STATE OF NORTH CAROLINA
DEPARTMENT OF TRANSPORTATION

Addendum No. 1

RE: Contract # C204333

US-70 (FUTURE I-42) FROM SR1003 (BUFFALO RD) TO WAYNE COUNTY LINE.

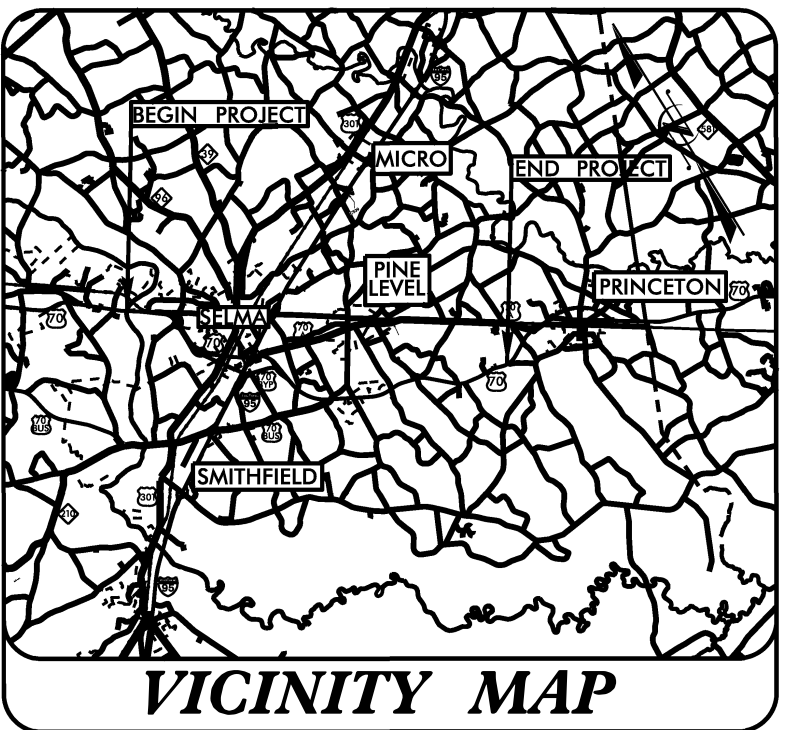
Sheet No.	Revisions
4	Revised to show correct map limits
